Application: SSI 7485

I write regarding the proposed modification to M4-M5 Link, Mod 2 The Crescent overpass and changes to pedestrian infrastructure in North Annandale, Rozelle and Rozelle Bay Foreshore area.

Figure 4-4 Elevation: Indicative view of The Crescent overpass

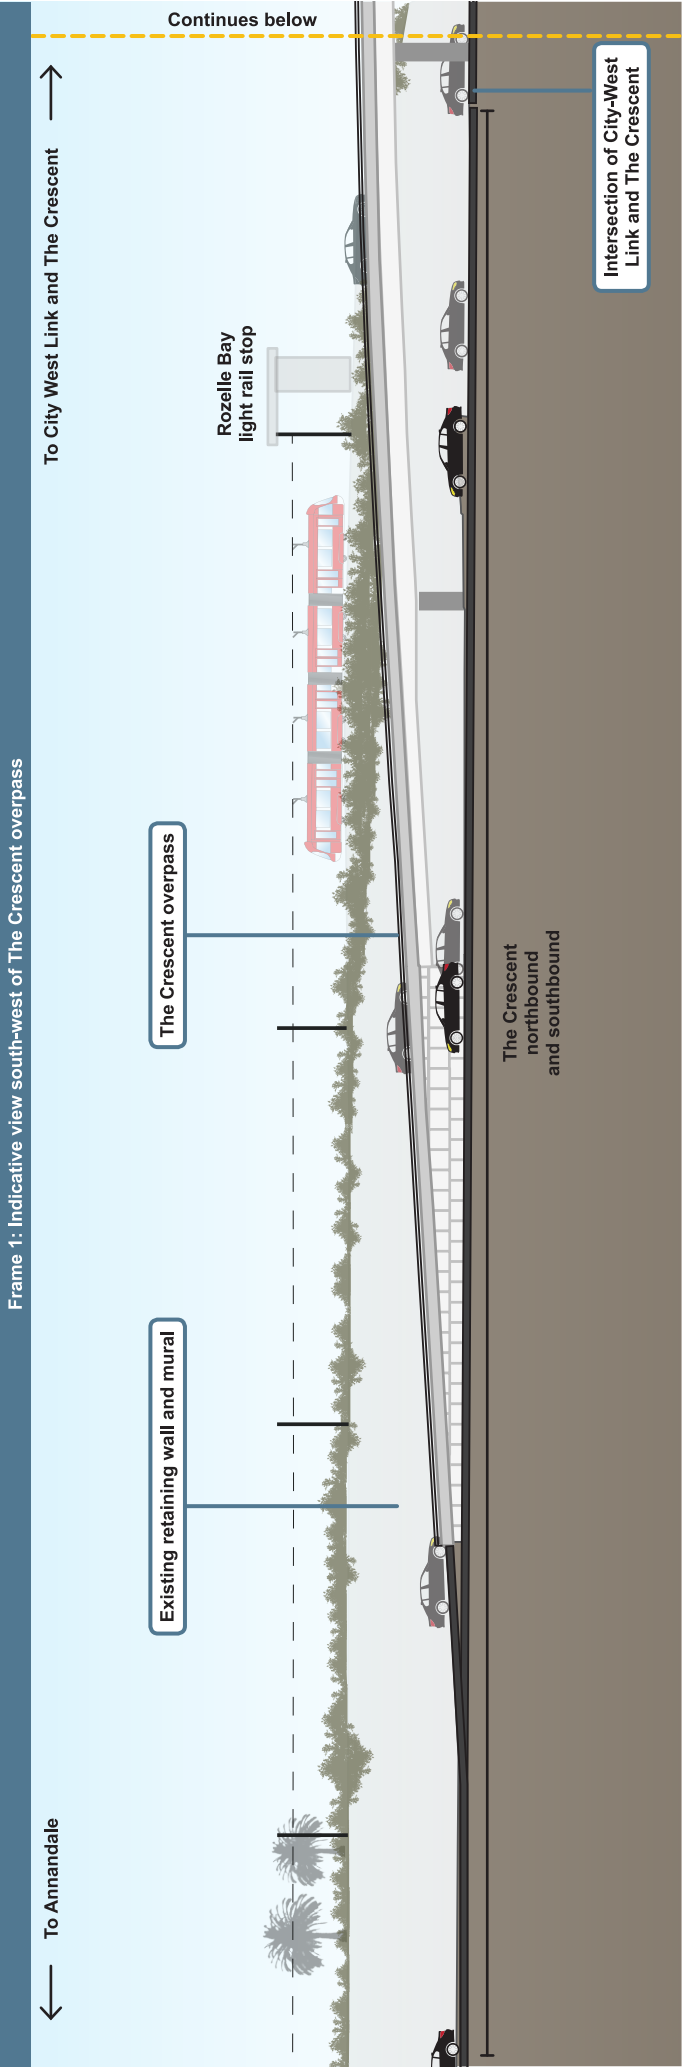
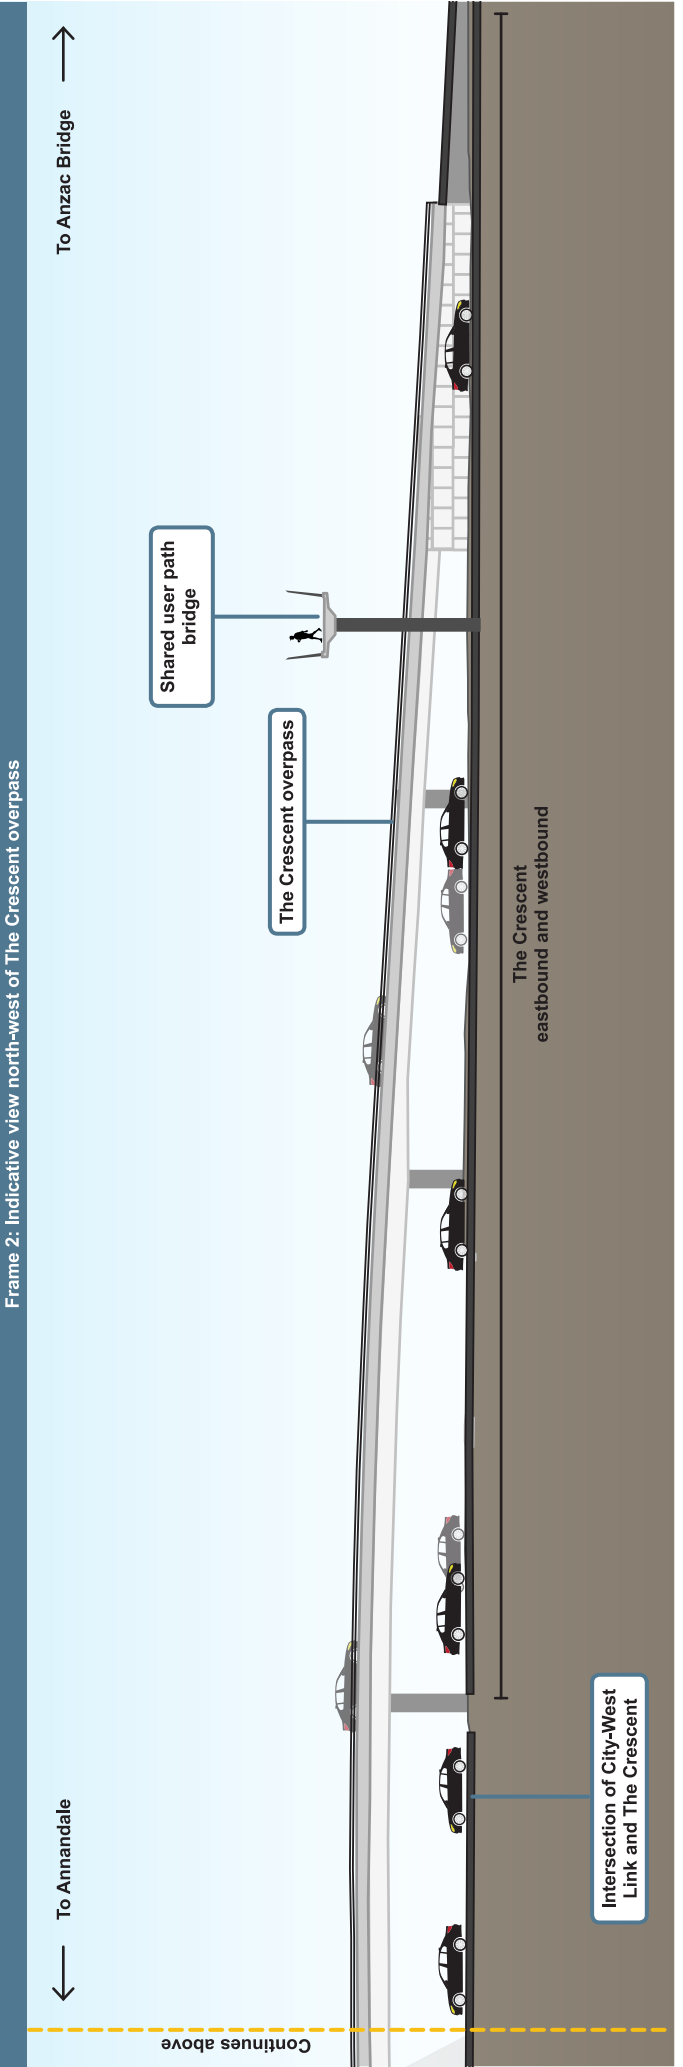
I request RMS work with the community to explore alternate design options to the proposed new car overpass design and the changed pedestrian and cyclist links. I am seeking the reinstatement of the safe, direct access from the approved EIS GreenLink to create a continuous green open space connection from the Rozelle Rail yards and Annandale to the foreshore. The GreenLink was more than just a walk way - it put people central to the design, maximising safety, and providing much needed accessible open space for the community now and into the future Bays Precinct design.

- The significantly reduced safety and increased risk for pedestrians and cyclists with removed access over The Crescent to Bicentennial Park and the increased traffic along Johnson Street.
- Being required to cross five sets of pedestrian lights at The Crescent as my option to reach the foreshore from Annandale or from Rozelle Bay light rail stop.
- Removal of direct active links to the foreshore, cutting the community off from the area and the proposed revitalisation of the entire Bays Precinct, including linking the Light Rail and Bus stops to a Ferry wharf and Metro station.
- Urban and landscape design that is being built before a finalised Masterplan for the area.
- Traffic changes that limit movements around the suburb and create further congestion in the local streets of Annandale, Forest Lodge, Glebe, Lilyfield and Rozelle with no planning to deal with these.

- Reinstate the GreenLink connecting communities and green open space from Rozelle to Bicentennial Park
- Relocate and design pedestrian and cyclist connections that are continuous, safe and direct.
- Design the modification infrastructure and active links in response to the character of the suburbs, the location of the foreshore and it's potential future development.
- Provide pedestrian and cyclist paths that maximise people safety and do not force them onto busier streets, unsafe concrete plazas and caged walkways.
- Integrate active and direct connections to all active transport - including the future Metro West and Foreshore Ferry Wharf
